Comments on the Applicant's Responses to Deadline 4 Submissions [part 11 – Response to Mr Moore and Dr Moore]

Unique Reference Number: 20040614

In their Section 2, which actually does relate to me, Tritax have responded to my document "Response to the Examining Authority's Written Questions and Request for Information ExQ1 Question 1.8.18 regarding the Applicant's methodology for noise assessment in the proposed Hinckley National Rail freight Interchange." of the 9th January 2024 (Deadline 4).

00:00 on 29/04/2021 to 13:00 on 29/04/2021

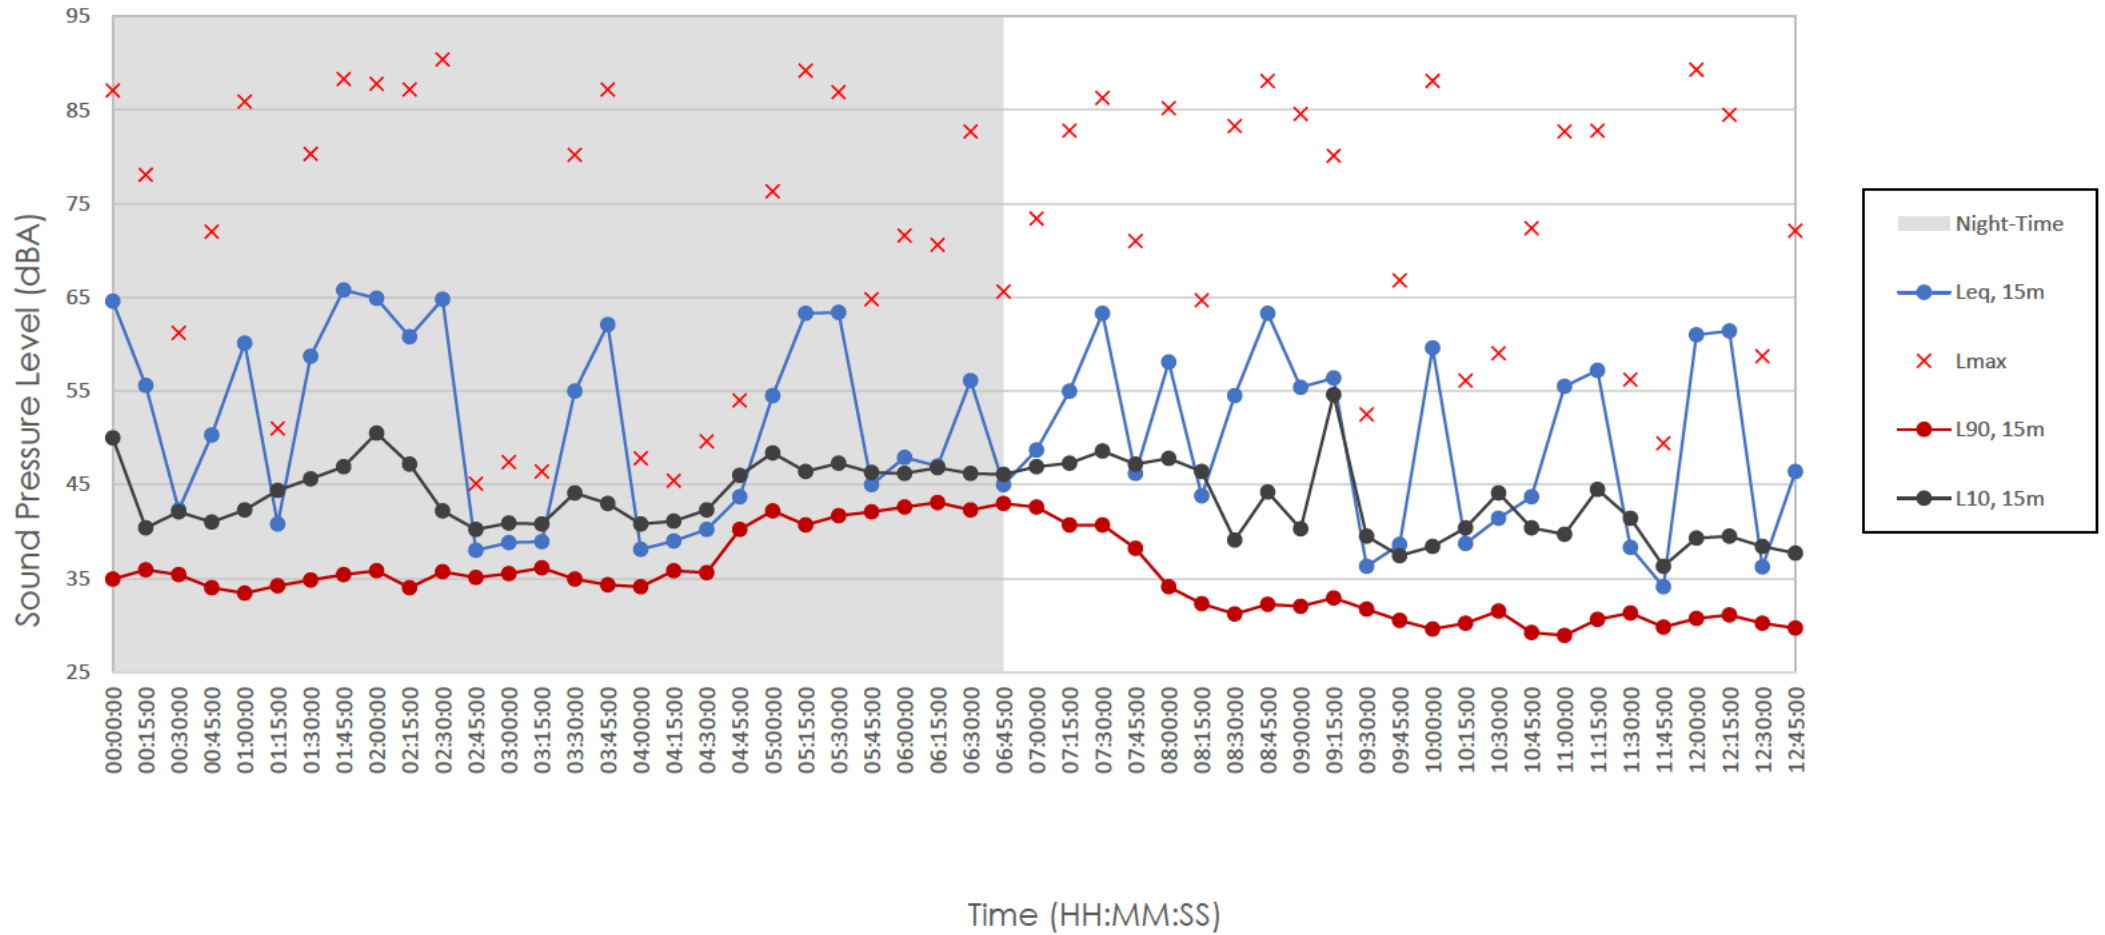
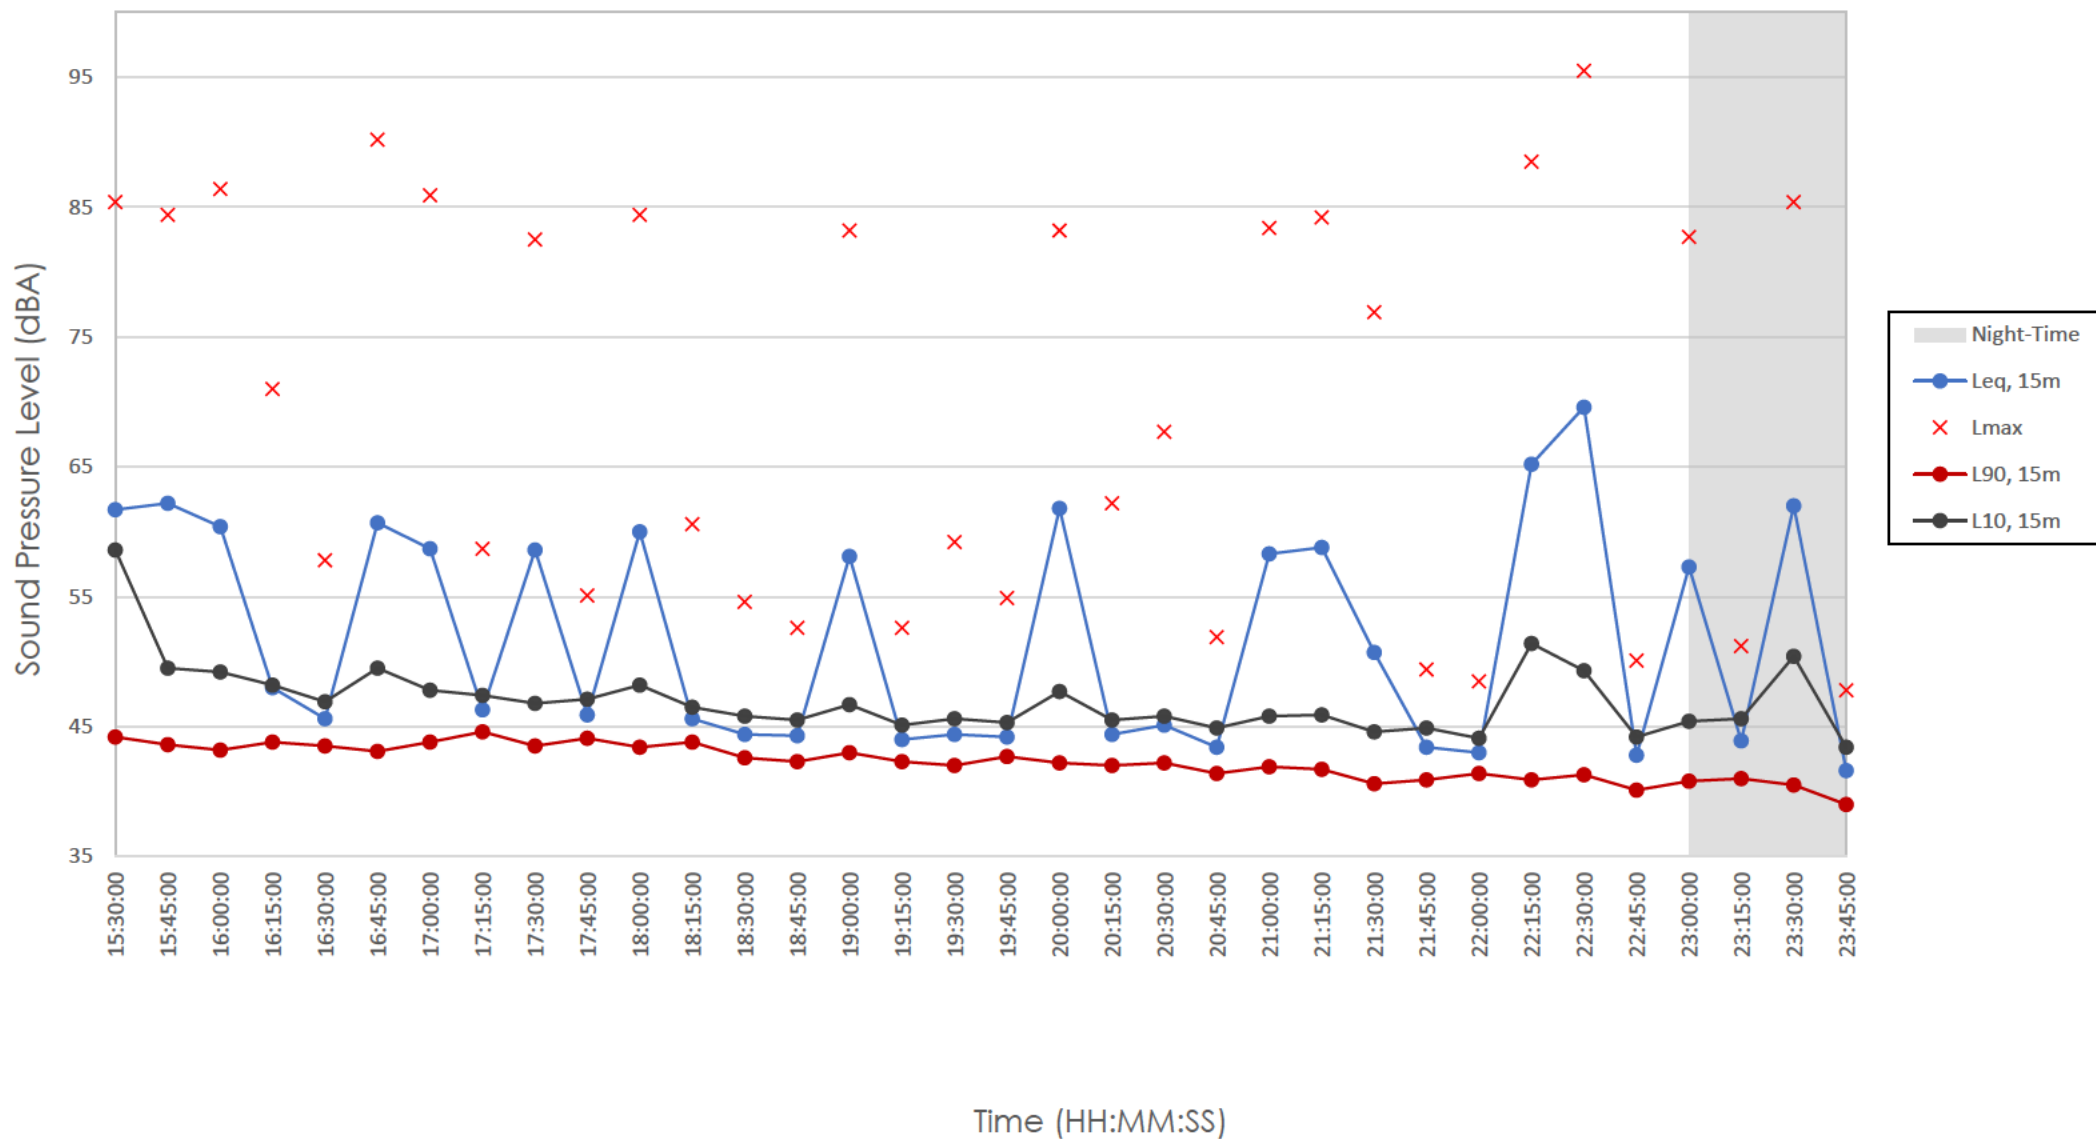
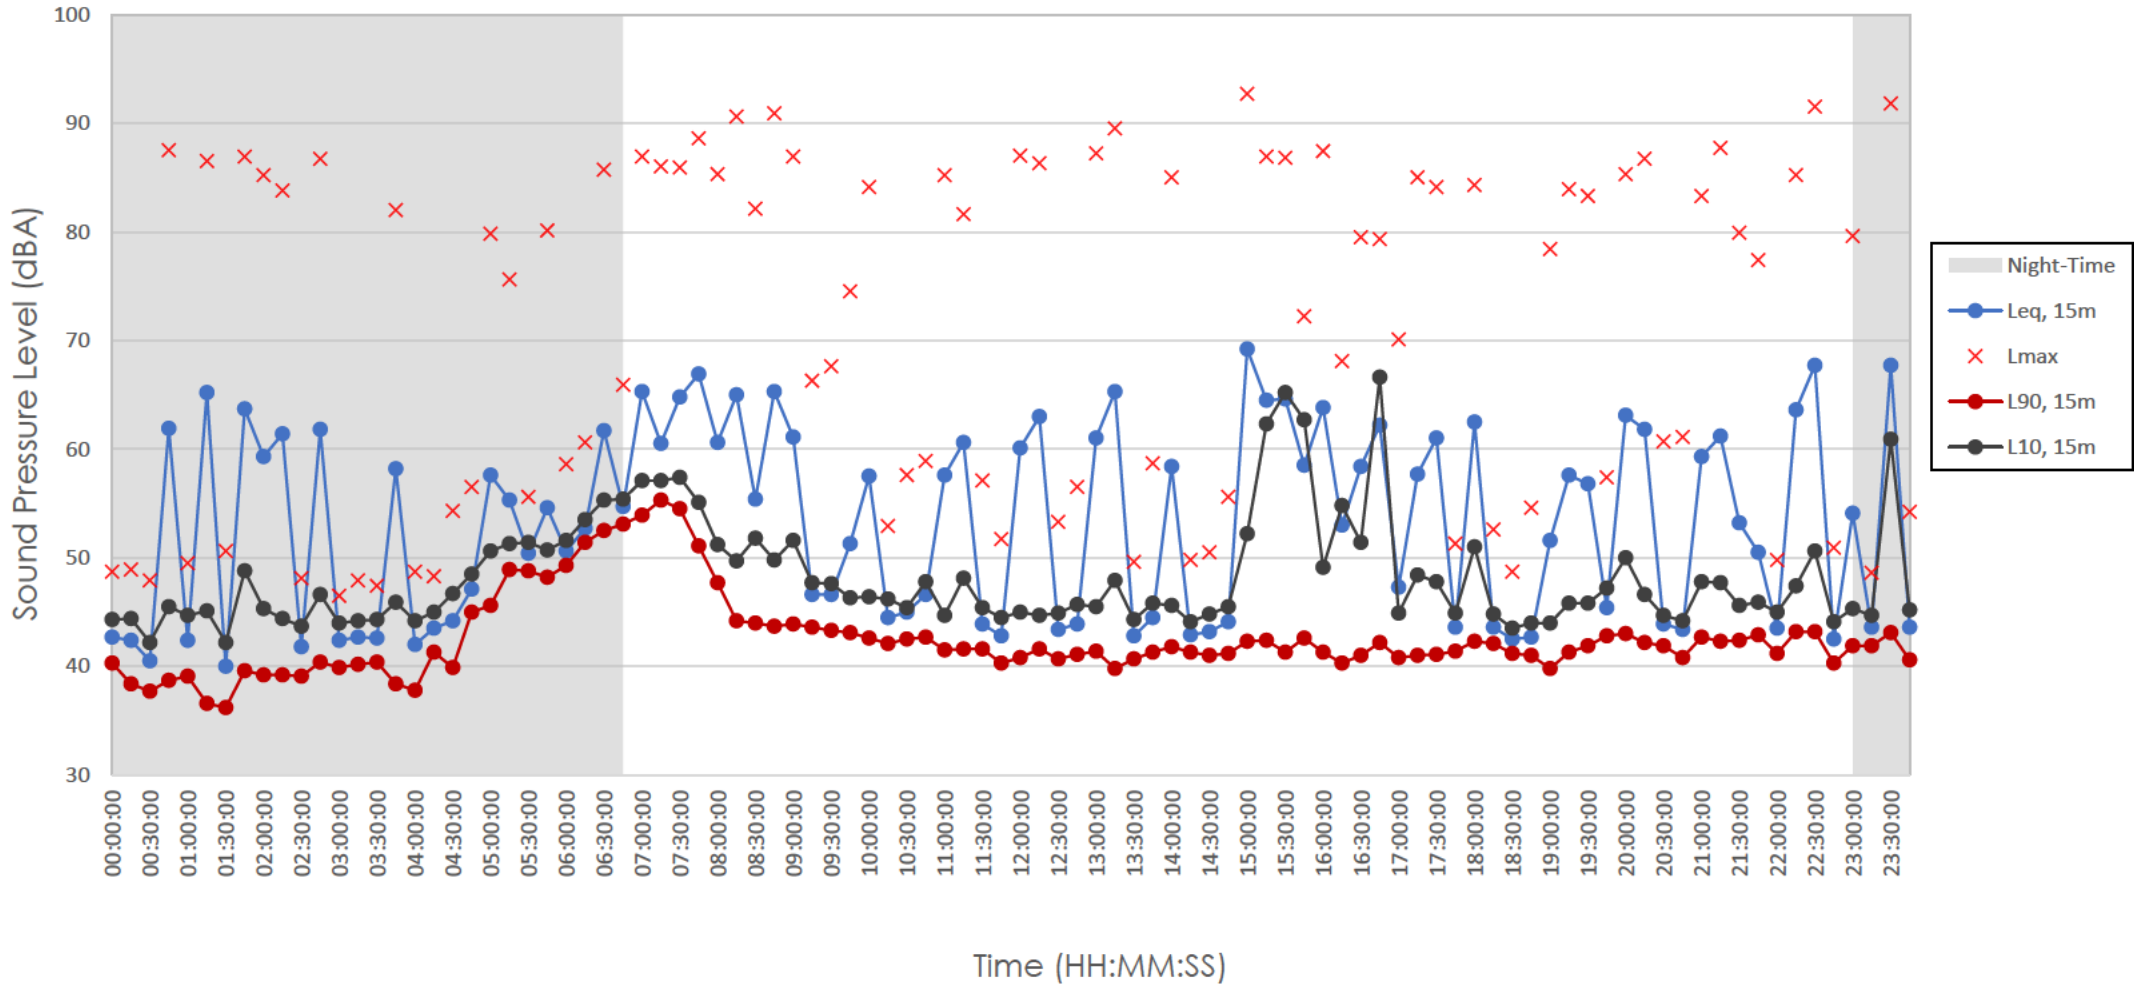
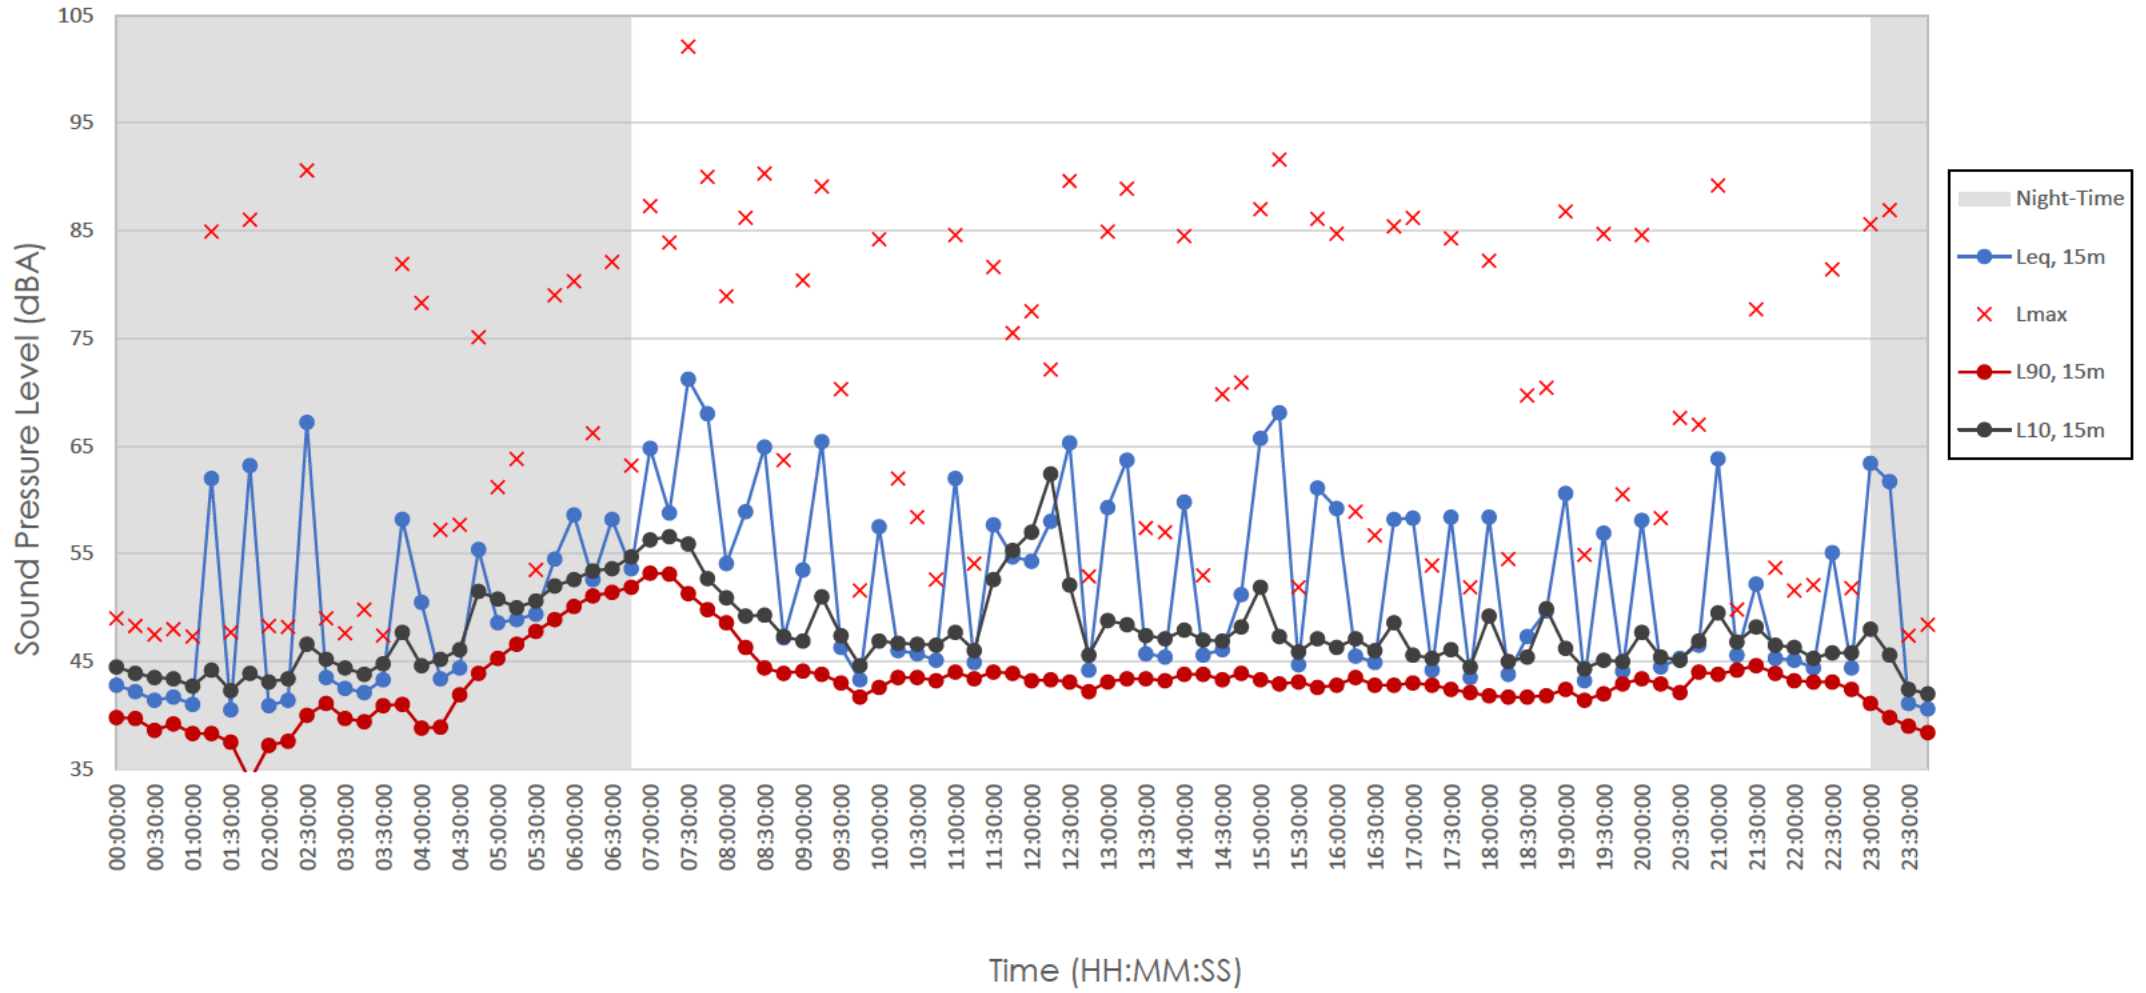
Moreover, the noise levels Tritax measured at the trackside and indicated in graphical form in Tritax’s ES Appendix 10.10 “Summary Results” are entirely in line with the train passby characteristics that I have indicated.

Tritax’s statement is incorrect, as I shall explain. The noise levels measured at the trackside over the 7-day period are continuous along the length of the line that is considered here, **and no rail noise maps are required**. Further, the DEFRA rail noise maps that Tritax have sought to introduce are intended for use only at a strategic level and are very much higher (12dB to 15dB) than the noise levels that Tritax measured at the trackside at NMP3 and NMP4 over the 7-day period and then used as a foundation of their Noise and vibration report.

Moreover, the DEFRA rail noise maps give no indication of the noise levels at Weekend daytimes or Weekend night-times, and indeed are so broad-brush that they indicate a **higher** rail noise level at night-time than daytime. In contrast, the noise levels Tritax measured at the trackside over the 7-day period give detailed information for both Weekends and Weekdays, and both daytime and night-time.
